**Consultation Response from KC,  
Lead Local Flood Authority**

**2024/91242 Land north east of, Shepley Road, Stocksmoor, Huddersfield, HD4 6XW**

**Erection of residential development (up to 50 dwellings) with associated access, parking, public open space, landscaping and infrastructure**

**Date Responded: 12/06/2024.**

Figure 2. Watercourse Location

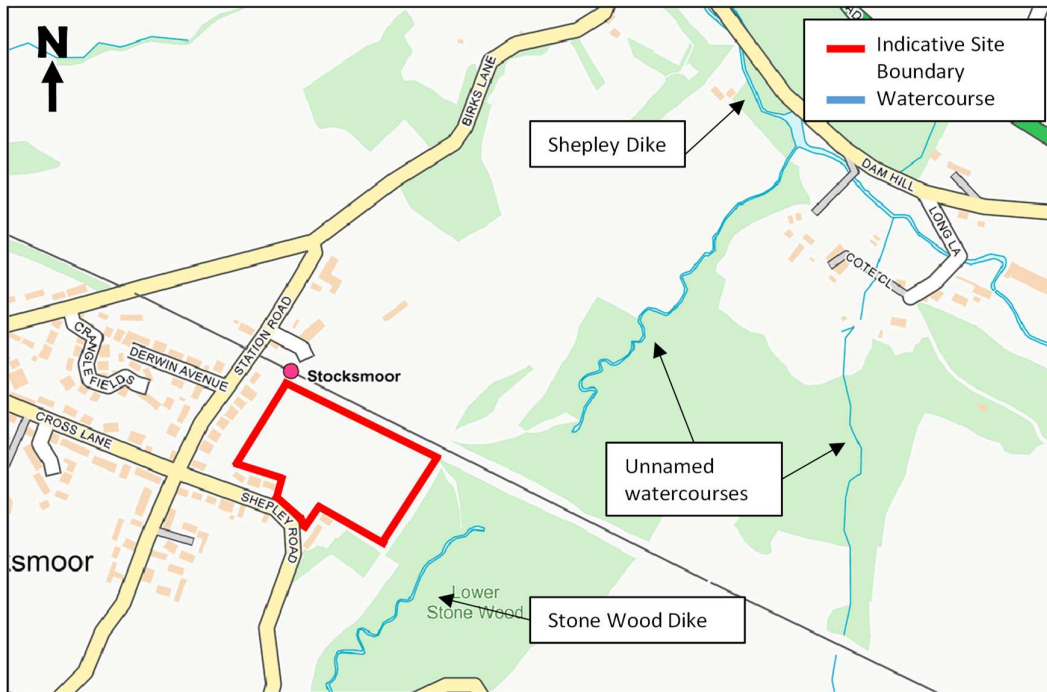
The submitted FRA contains an Outline Drainage Strategy. The LLFA agrees that as the site is located within FZ1, a sequential test is not required and the Flood Risk Impacts are low. In addition, the LLFA considers infiltration into the underlying soil as not being feasible due to the steeply sloping ground to the east of the development and the risk of re-emergence of flows that could de-stabilise the slope. Therefore, the LLFA accepts the proposal to discharge attenuated surface water flows to a local unnamed watercourse to the east of the site (a tributary of Stone Wood Dike) as shown on the plan in Appendix B of the FRA.
